DELEGATED DECISION TO DETERMINE PLANNING APPLICATIONS

Reference No:	2026/62/91480/W
Site Address:	Moss Edge Farm, Moss Edge Road, Holmbridge, Holmfirth, HD9 2SD
Description:	Erection of garage extension and change of use of land from agricultural to residential
Recommending Officer:	Joanna Rednall

DECISION - REFUSED

Site Plan Proposed

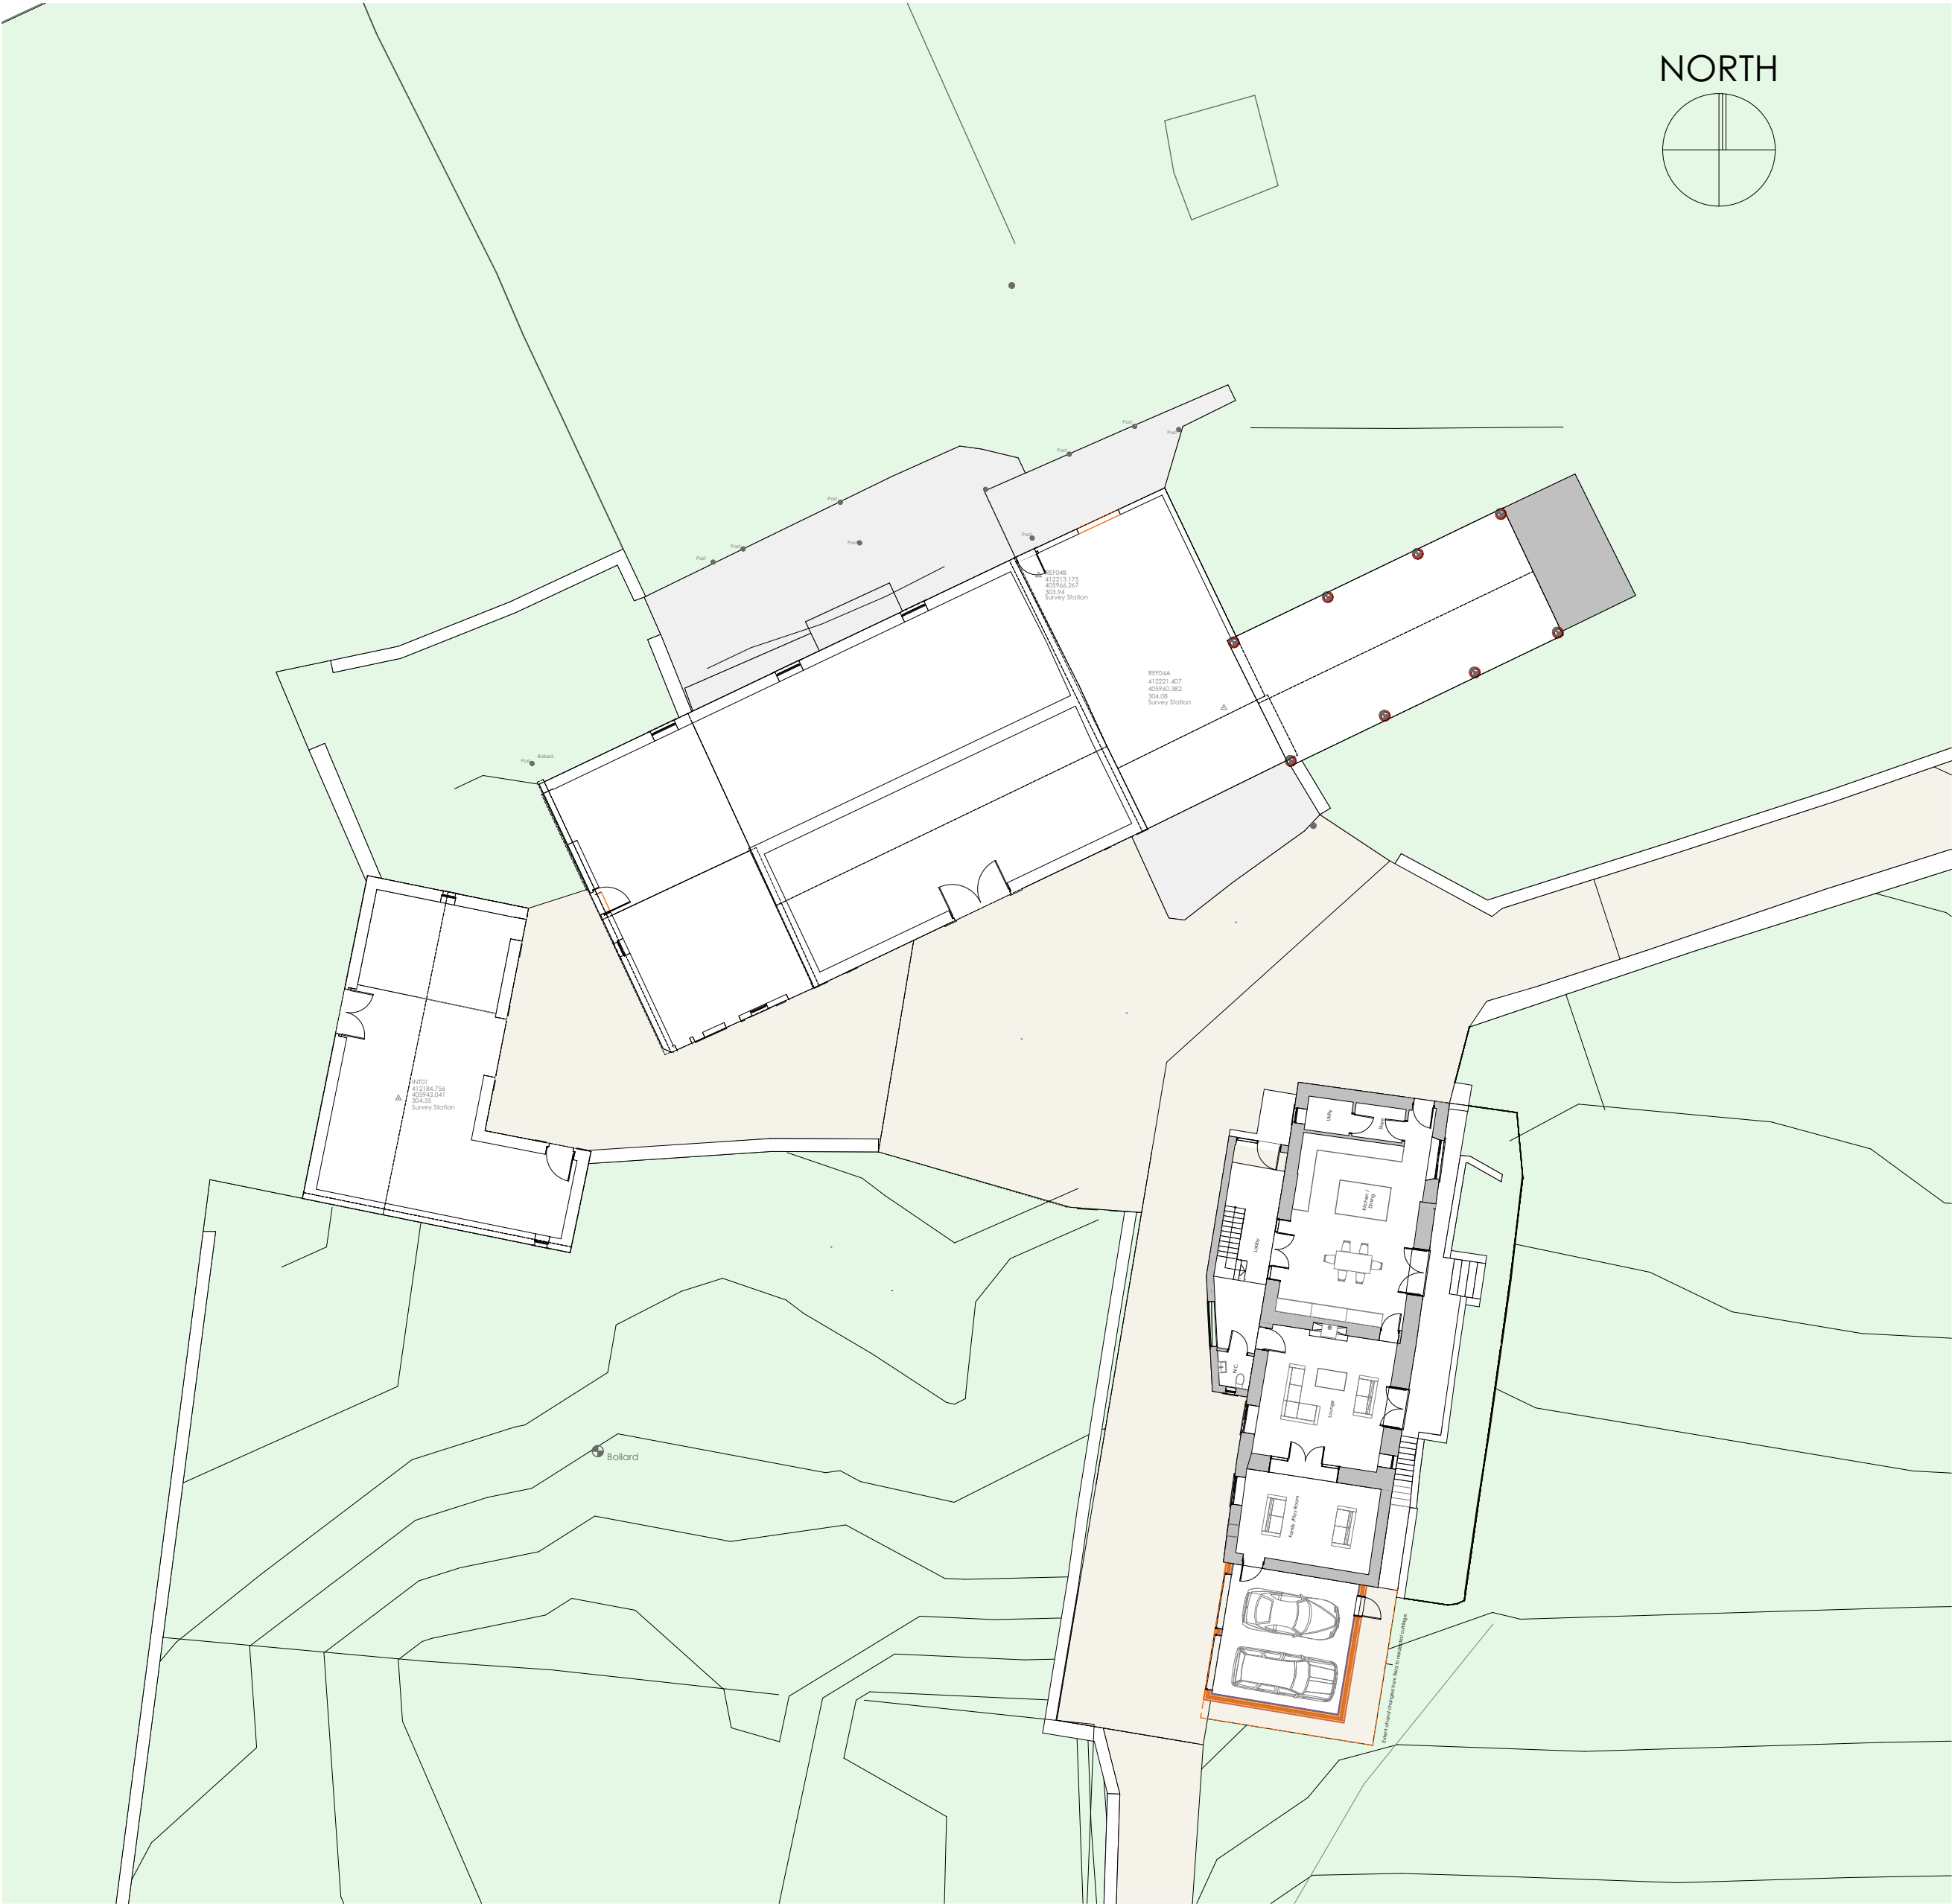
In this case the proposal would see encroachment into the Green Belt conflicting with one of the purposes of including land within the Green Belt, the extent of the encroachment goes beyond the established building line whereby built form of residential properties is up to the Green Belt boundary rather than within it.

The encroachment of built form as a result of hardstanding areas and extensions proposed as part of this application has a harmful impact eroding the openness of the Green Belt through the introduction of urban features in a part of the site which was previously free from development and contributed to the wider openness of this part of the Green Belt. The proposal is therefore considered to have a visually harmful impact in this regard in relation to the openness of the Green Belt and is also considered to have a harmful impact by reason of inappropriateness given it relates to inappropriate development within the Green Belt.

In this case, the proposed extension is modest in scale and would not exceed two-thirds of the width of the host dwelling. It would have a maximum height of no more than 4m and would be set back by 0.2m from the principal elevation, providing a subtle visual break between the original dwelling and the extension.

However, despite the above considerations, officers consider the principle of the side extension would be unacceptable in this case. This is because the development as a whole would constitute inappropriate development in the Green Belt in terms of extending the residential curtilage and encroachment into the countryside, contrary to the aims of paragraph 143c of the NPPF.
